From: Amber Willard
Sent: 06 June 2018 09:37
To: Karen Parsons
Subject: FW: LU/81/18/HH
Attachments: North Ham Road 31-Block Plan.pdf

From: Amber Willard
Sent: 04 June 2018 09:11
To: [REDACTED]
Subject: LU/81/18/HH

I am the officer on your application LU/81/18/HH at 31 North Ham Road and I have just received WSCC consultation, in which additional plans have been requested.

DRAWING	SCALE
BLOCK PLAN	1/200
DATE: MARCH 2018	
DRAWN: T. Murray	
DRAWING: 18/07/3	REVISION:

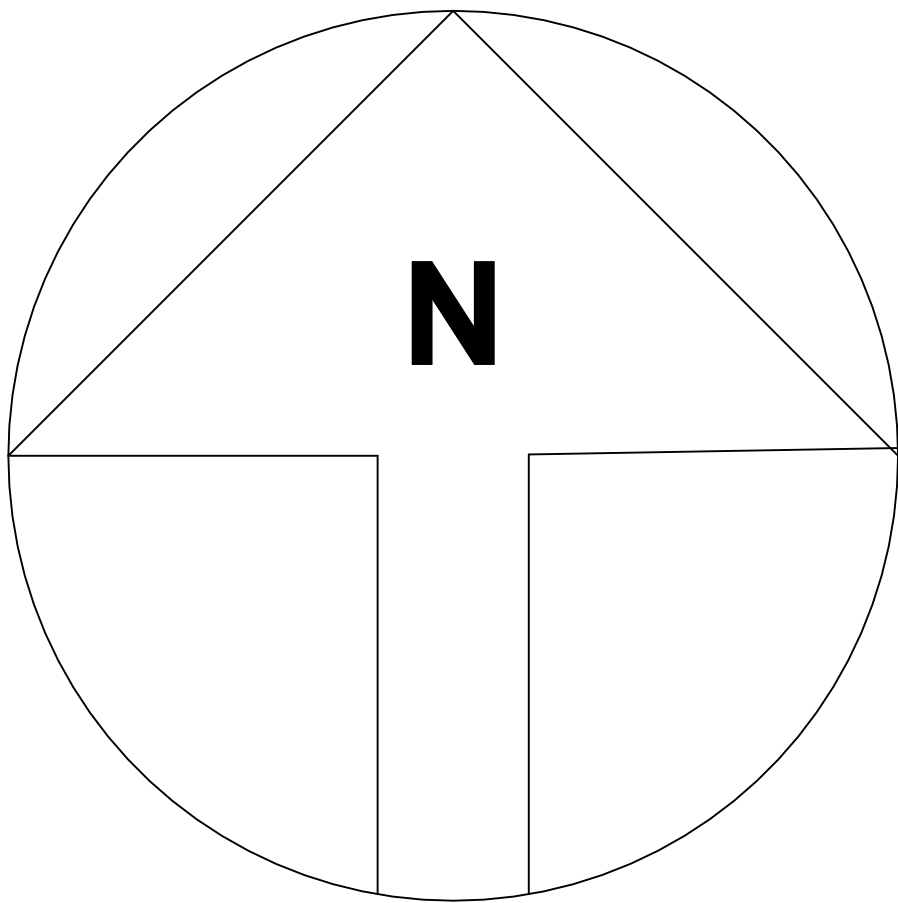
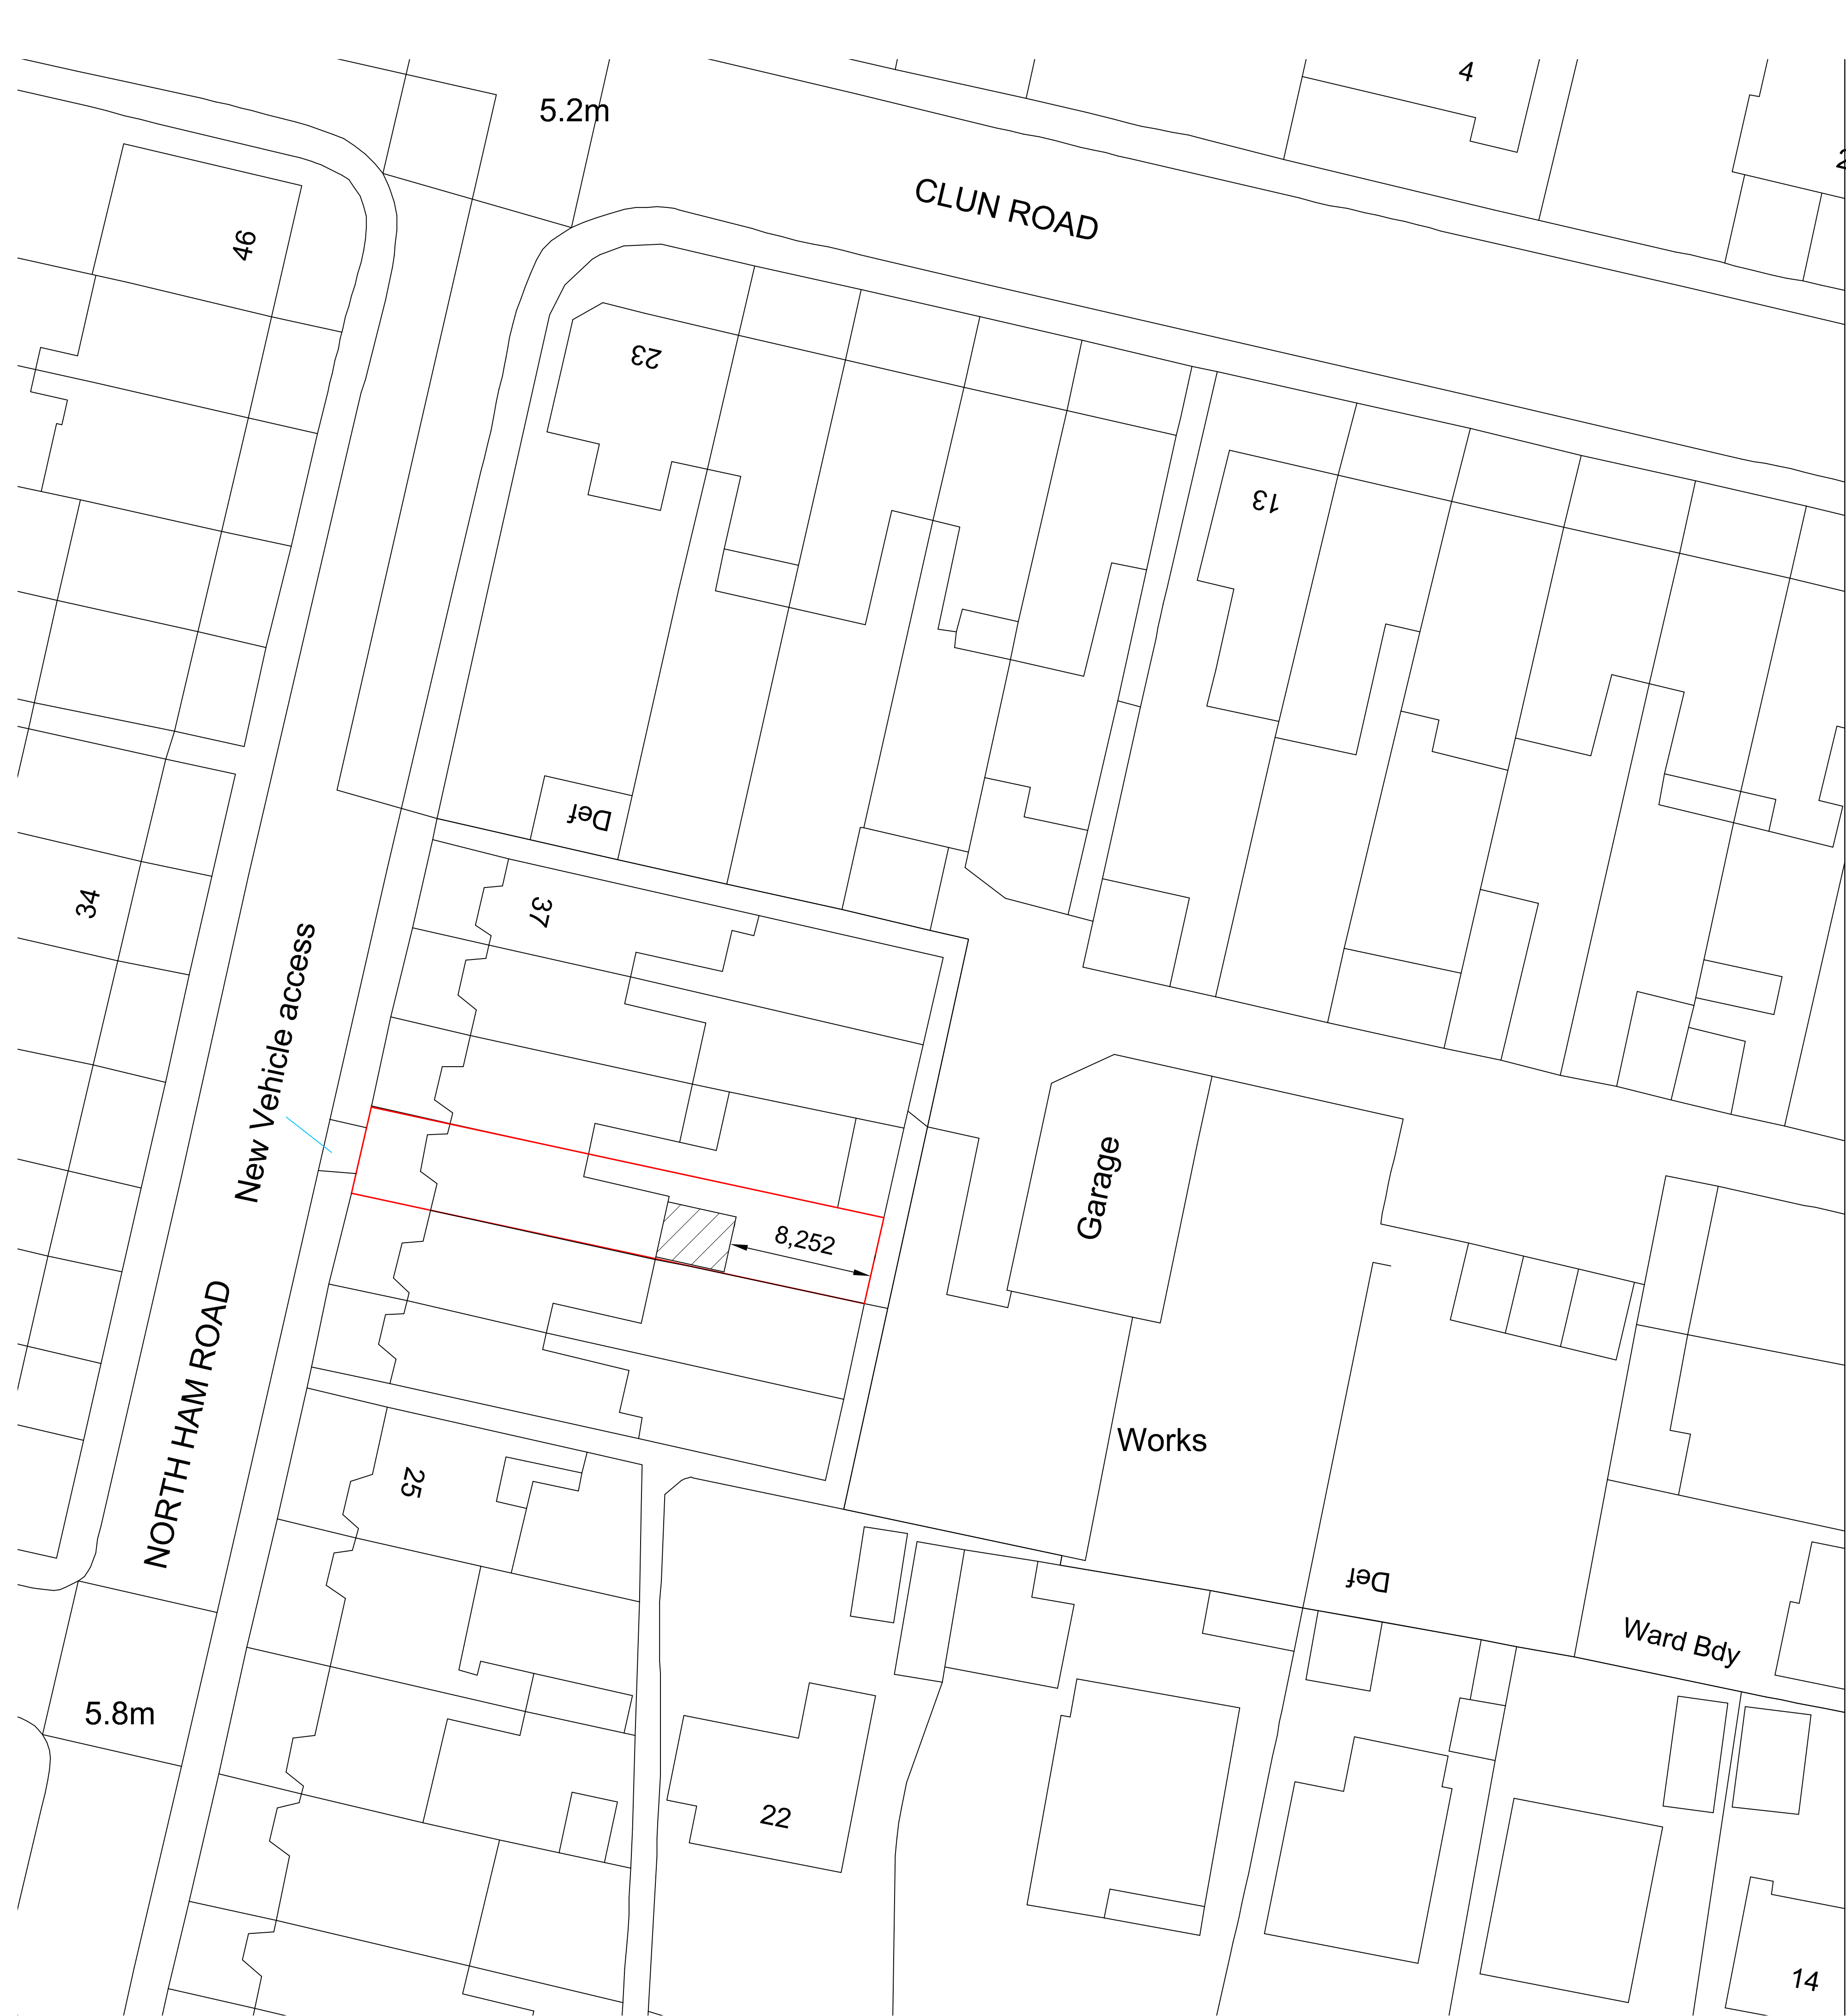
An additional plan demonstrating the size of any proposed hardstanding area is required. It is advised that 2.4 x 4.8 metres of hardstanding is required to fully remove a vehicle from the carriageway / footway.

Please find attached amended block plan and please note that I agree to an extension of time until June 15th.
